**Consultation Response from KC,
Highways Development Management****2025/90557 101, New Street, Huddersfield, HD1 2TW****Alterations to first floor store to form 4 flats****Date Responded: 04/06/2025****Responding Officer: CNB****Responding Ref: K5-7SW/32**

This application is for alterations to a first-floor store area above a retail development to form 4 residential dwellings. The site is on New Street, a part of the Huddersfield town centre pedestrianised zone.

Drawing
No:
2043- P 01

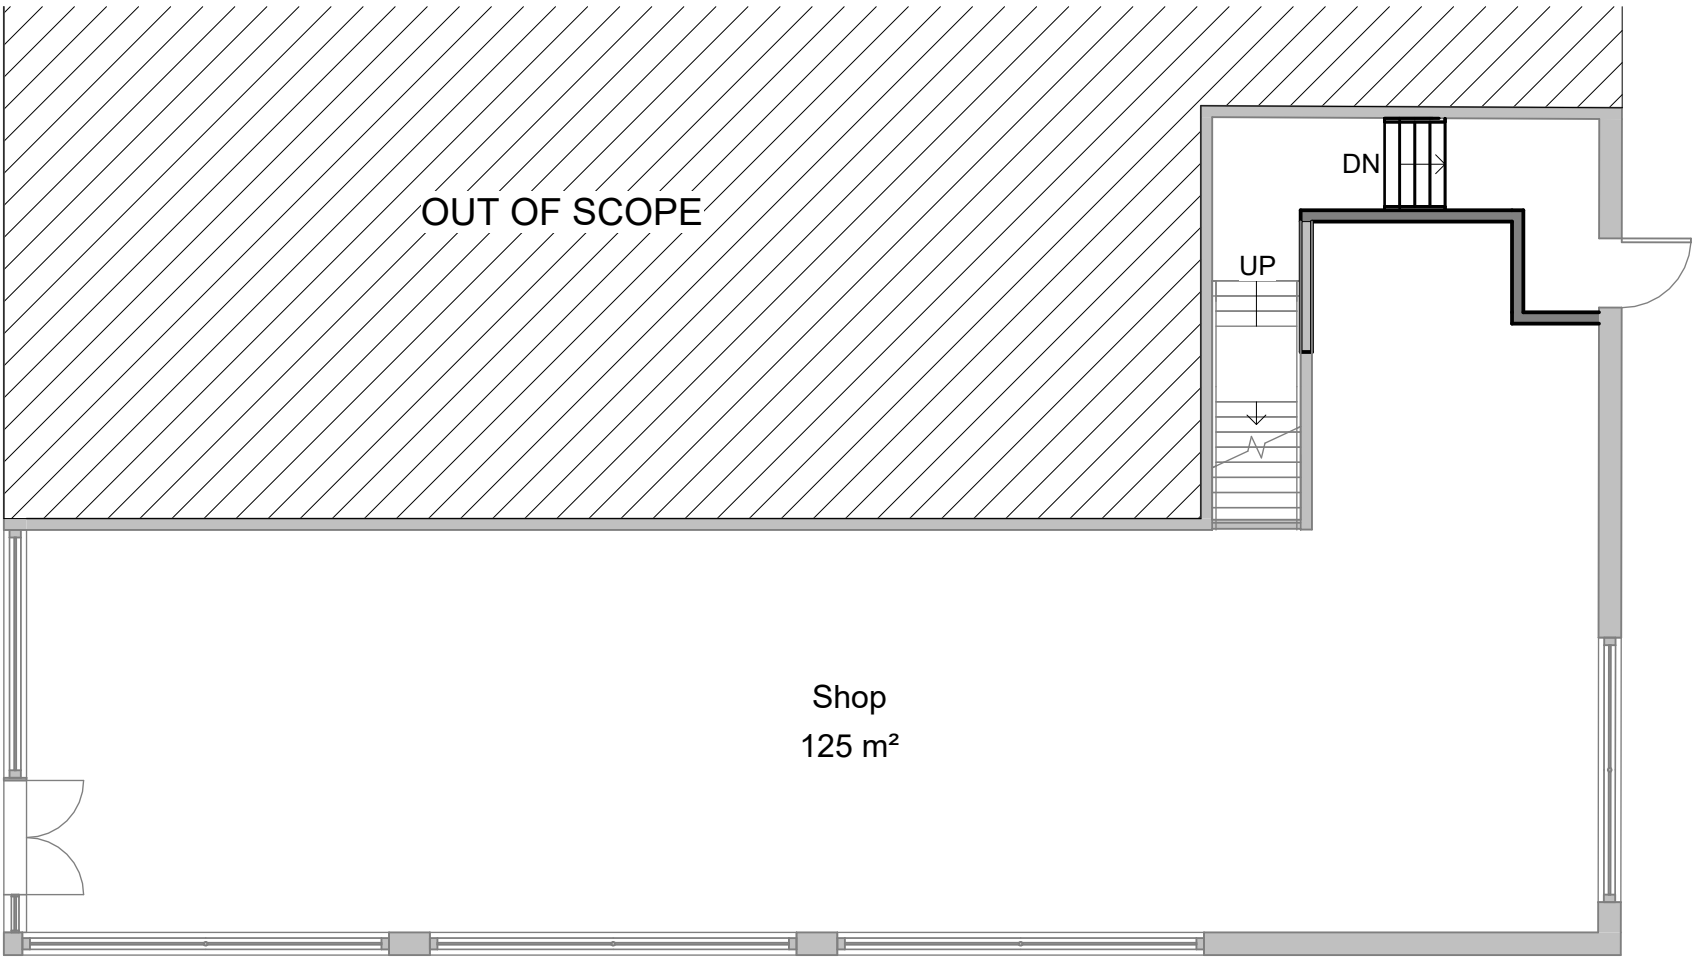
No details were provided relating to cycle storage at the site. Without any car parking we would like to see cycle storage provided to local standards of 1 space per dwelling and so we would wish to see safe and secure storage for 4 cycles provided with the development. This should be conditioned.

No details were provided for waste storage and collection, this is a concern due to the town centre location of the site. Suitable space for waste and recycling storage should be provided within the site and we would request that the details are submitted to the Kirklees waste strategy team for their approval and also the location of a suitable collection presentation point for bins should be clearly indicated on a drawing to ensure that it is accessible for a Kirklees waste collection vehicle. We would not support any development that requires waste to be stored on the footway outside the development site for highway safety reasons.

With this we cannot fully assess the impacts of the development on the surrounding highway and footway network and so must object on these grounds. If the applicant can provide details of suitable cycle and waste storage, then we may be able to reassess the application.
